Our Ref: EN010128

Date: 18 April 2024

Application by Cory Environmental Holdings Limited (CEHL) for an Order Granting Development Consent for the Cory Decarbonisation project (EN010128)

Advice following issue of decision to accept the application for examination

EXTENDED CROSSNESS LOCAL NATURE RESERVE PLAN: 2.9

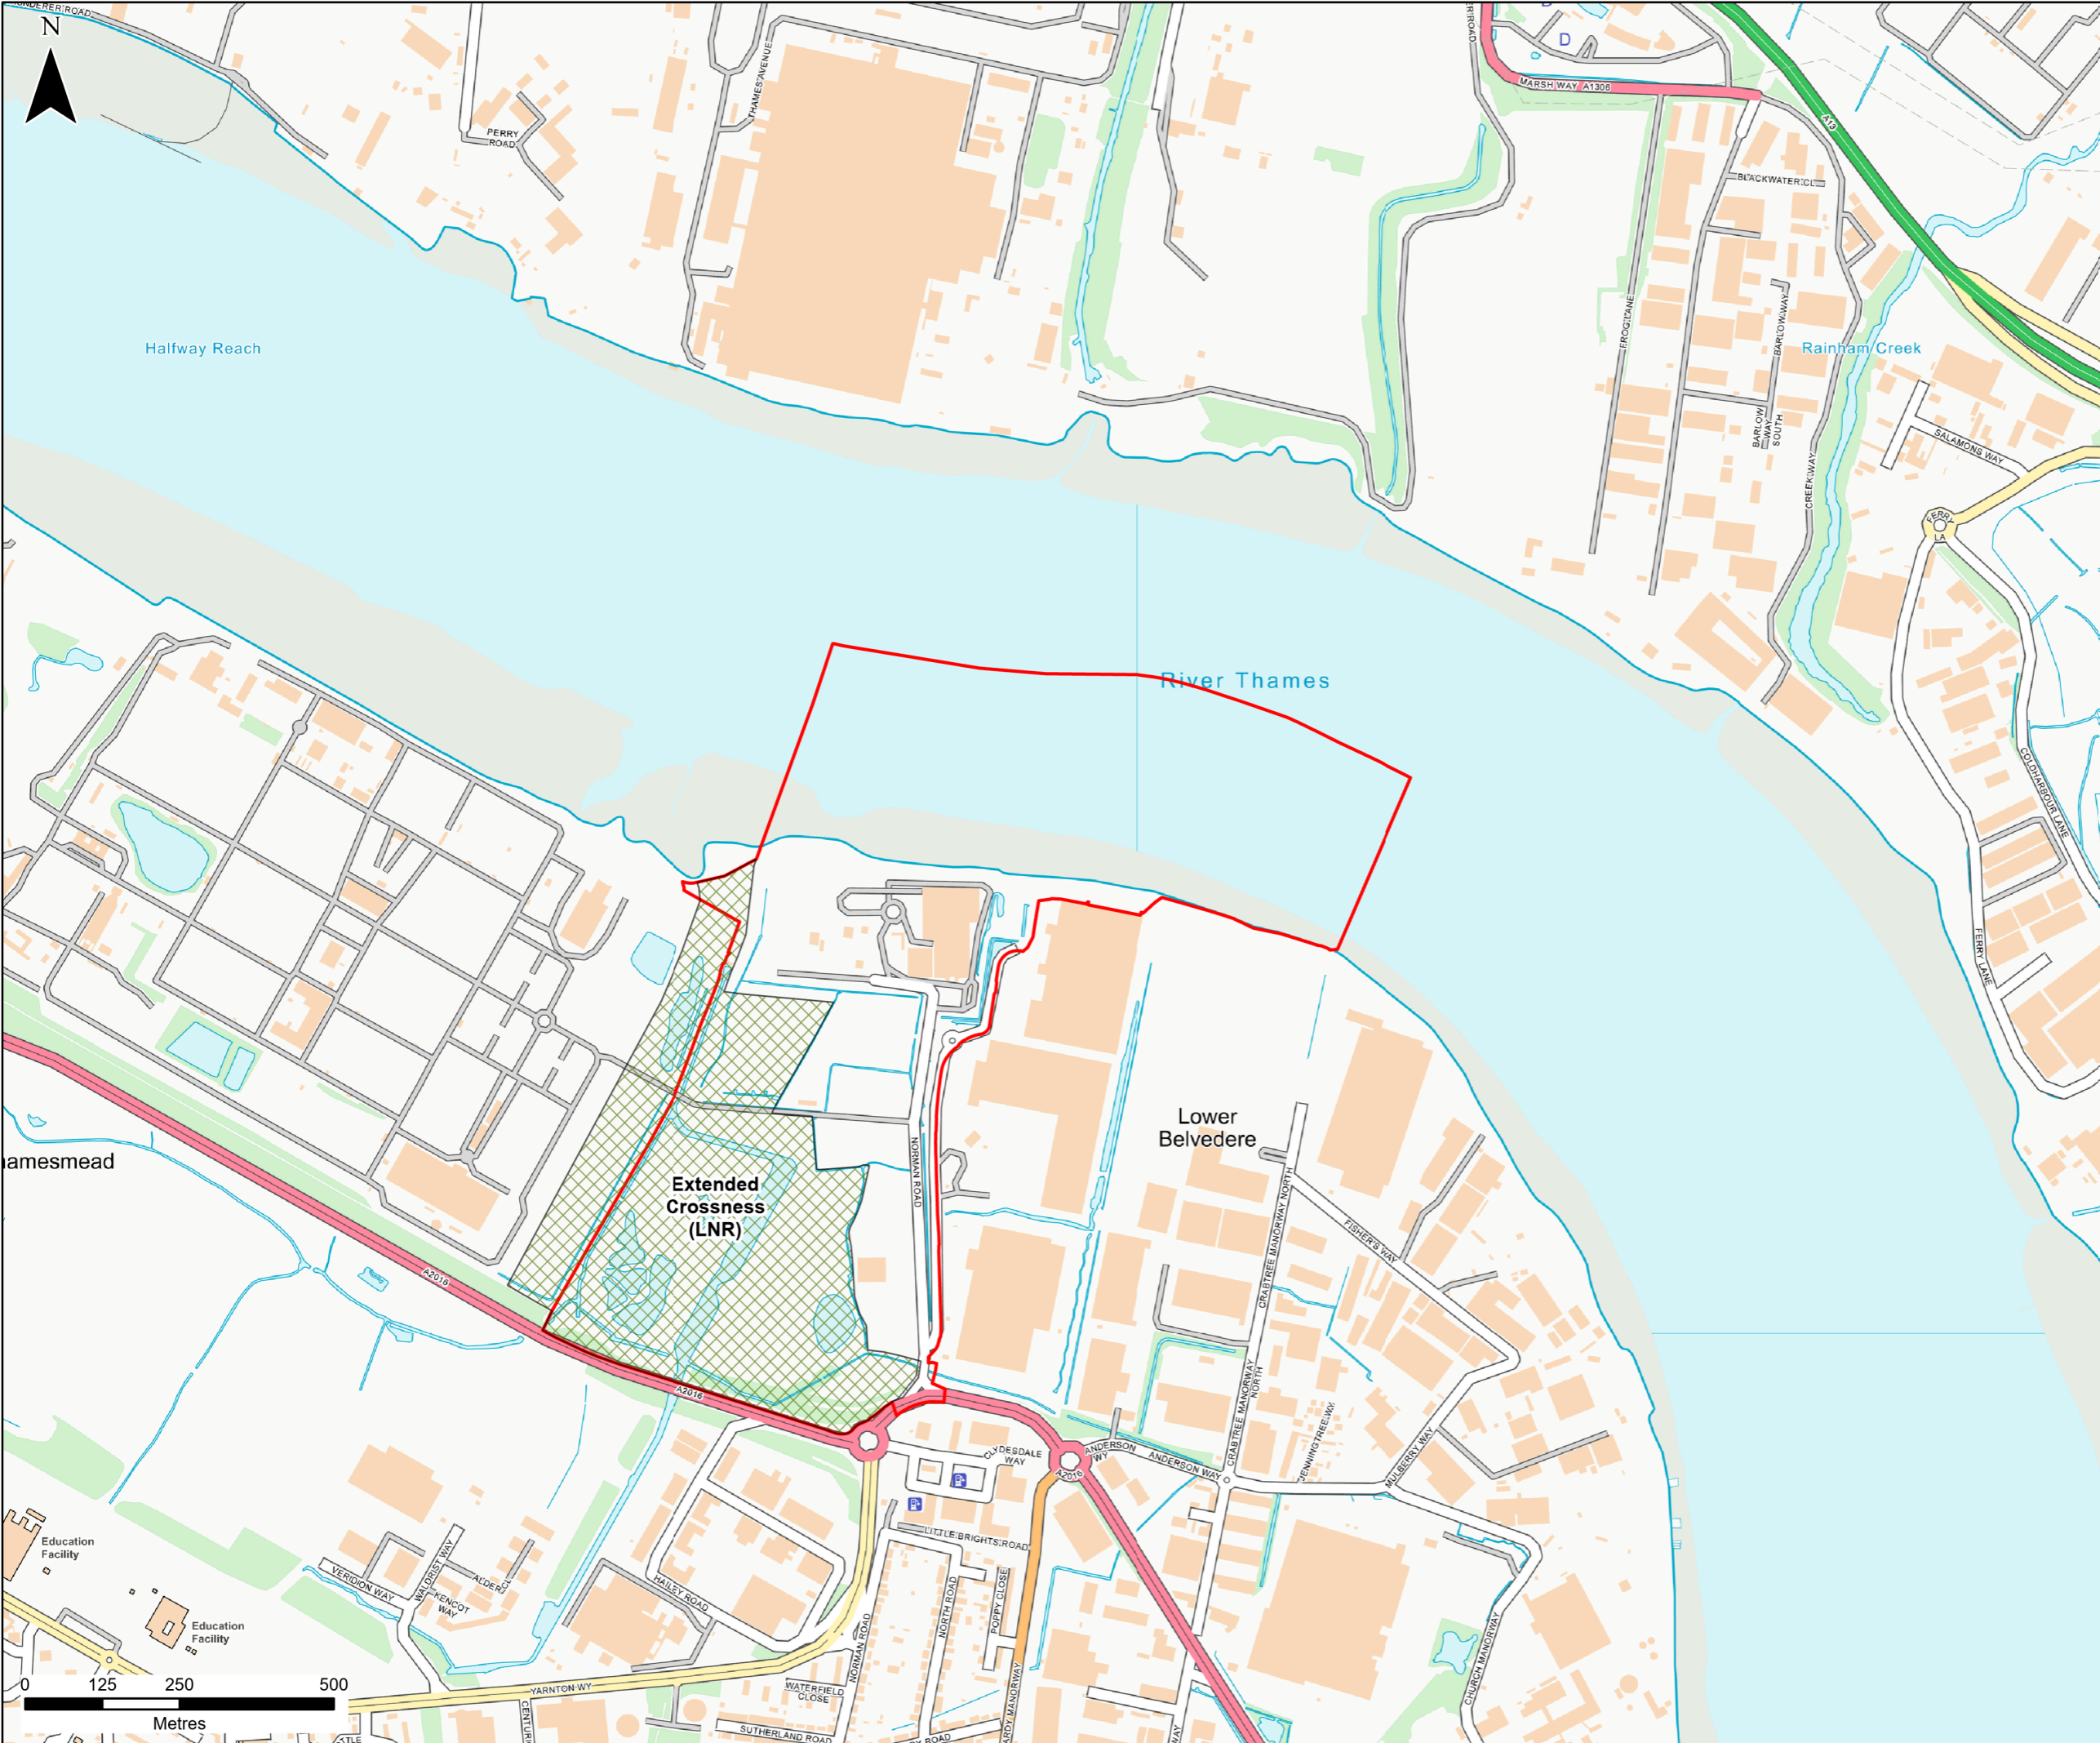
There appears to be a variety of map bases: the local nature reserve plan has adequate labelling but on most of the other plans the mapping is very faint and background detail eg street names and locations are missing, which makes it difficult for the reader to identify features; we would suggest a common map base for all plans which is clear, legible and well labelled.
